Planning Application Ref: FG/8/21/T

Location: 166 Littlehampton Road, Ferring, BN12 6PH

Description of works: 2no. hornbeam (T1 & T3) - Crown lift lower canopy to approximately 3m on 166 Littlehampton Rd. boundary, not exceeding diameter of 100mm. 1no. ash tree (T2) - Reduce back lateral spread on 166 Littlehampton Rd boundary, not exceeding diameter of 100mm

166 Littlehampton
Rd
Boundary in RED

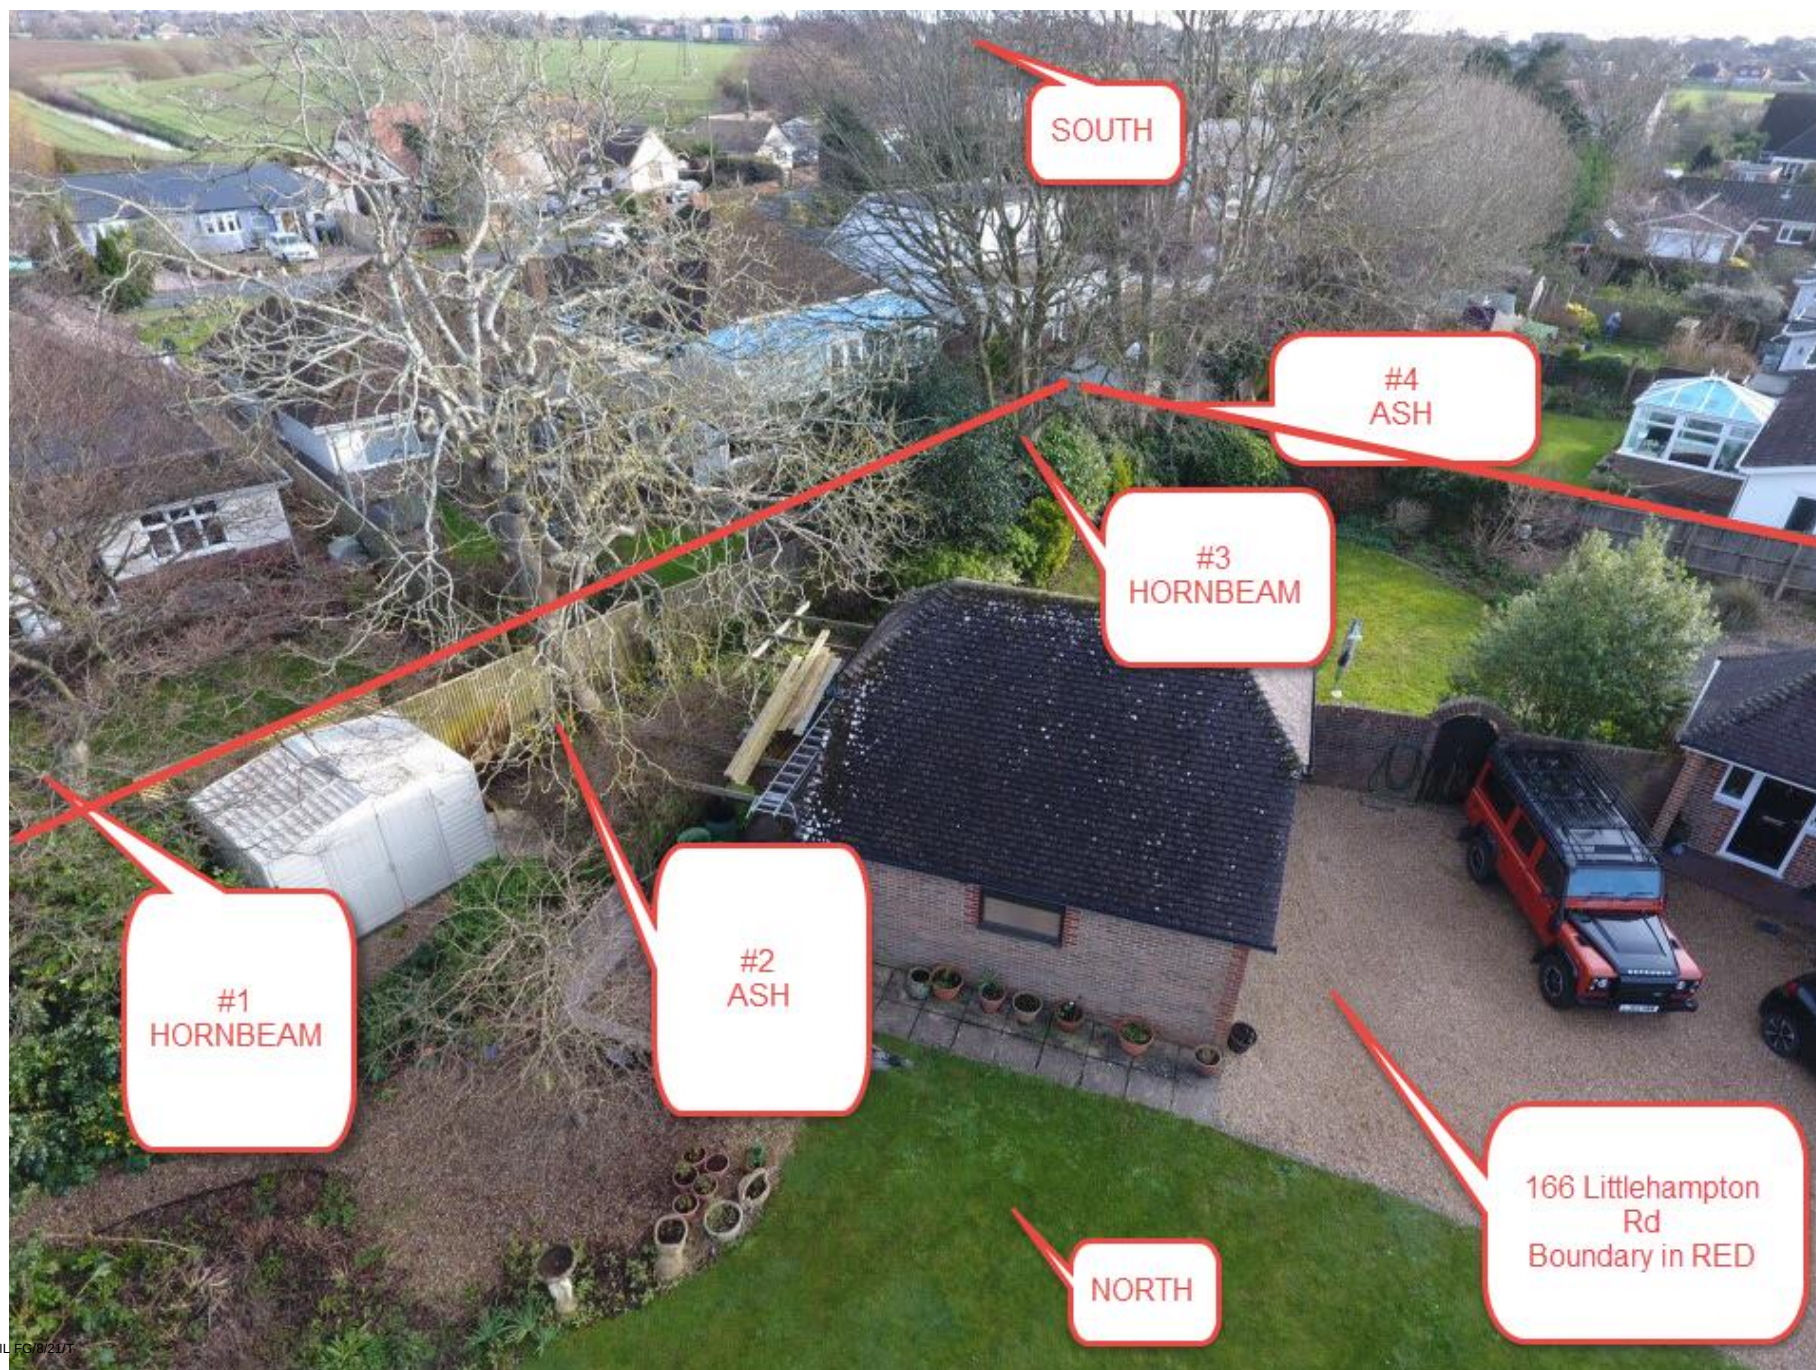
- Outwardly and from distance (roadside) these trees appear to be in a fine physiological state (and assumed to be so in the absence of any information/evidence provided to the contrary).
- Although they grow at the rear of the property, they can be seen from surrounding dwellings and public highway (footway and carriageway). As such, they have high amenity value.

- The work proposed is justified on arboricultural grounds as it seeks to strike a balance between the trees influence and potential impact on surrounding residential property and the need to retain them with dignity by having respect for natural form.
- If the work is undertaken to a high standard there should be no long-term harm to their health and vitality.

- I recommend **CONSENT** for this application, subject to the following condition:

- Part a) Where whole branches are to be removed and final cuts made close to the trunk or branch union they are to be made as shown in Figure 2 of BS3998:2010
- Part b) Where branches are to be shortened back the final cuts are to be made at the correct angle shown in BS3998:2010 and adjacent to a live bud or lateral.
